**\*PRE-HEARING STAFF ANALYSIS\***

**Rezoning Petition No. 2008-055**

**Petitioner:** Merrifield Partners, LLC

**Request:** O-1(CD) S.P.A., office conditional site plan amendment.

CRAB ORCHARD TNSHP.
MECKLENBURG COUNTY, NORTH CAROLINA
**TECHNICAL DATA SHEET FOR
PETITION NO. 99-16C**

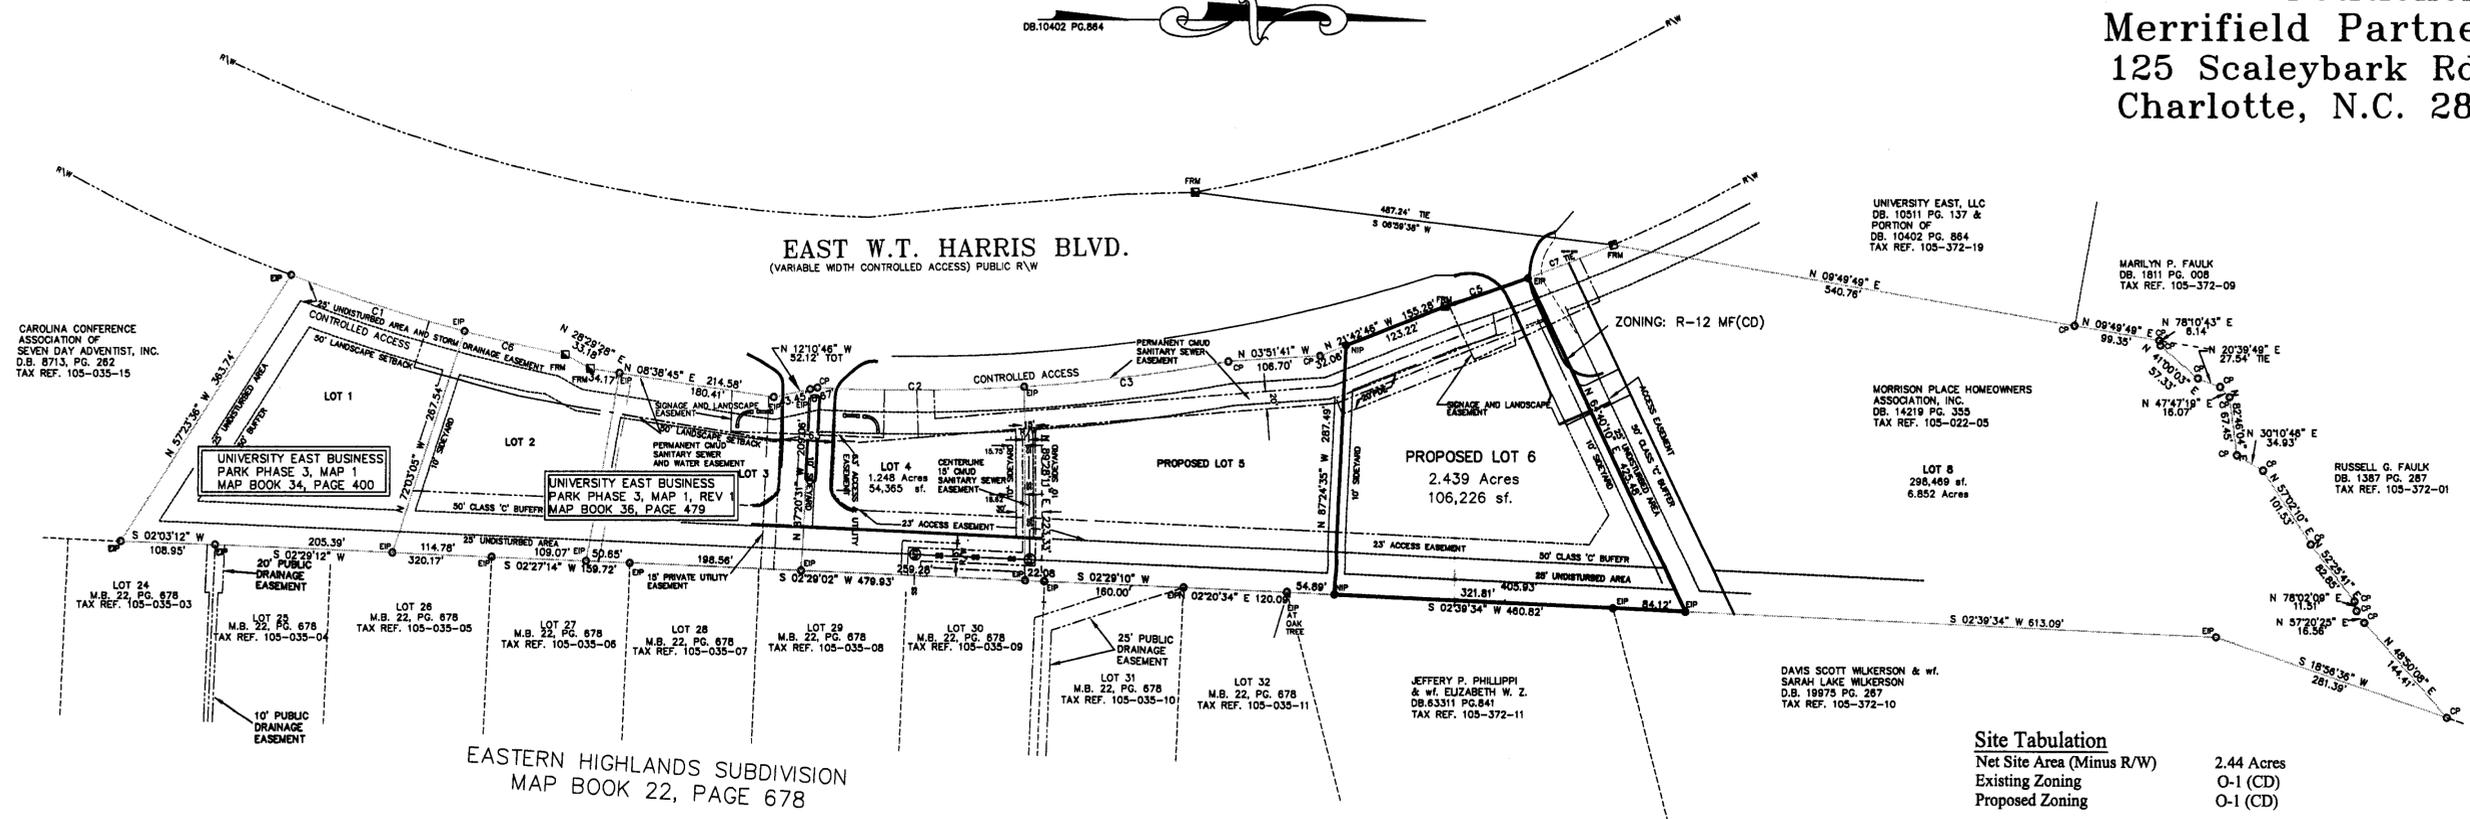
**Site plan.** The following site plan comments are outstanding:

- The site plan should have a note that play space will not be located between the building and W.T. Harris Boulevard.
- Under the General Provisions section: Mecklenburg County Zoning Ordinance should be changed to “City of Charlotte Zoning Ordinance.”
- The petitioner needs to address outstanding LUESA issues.
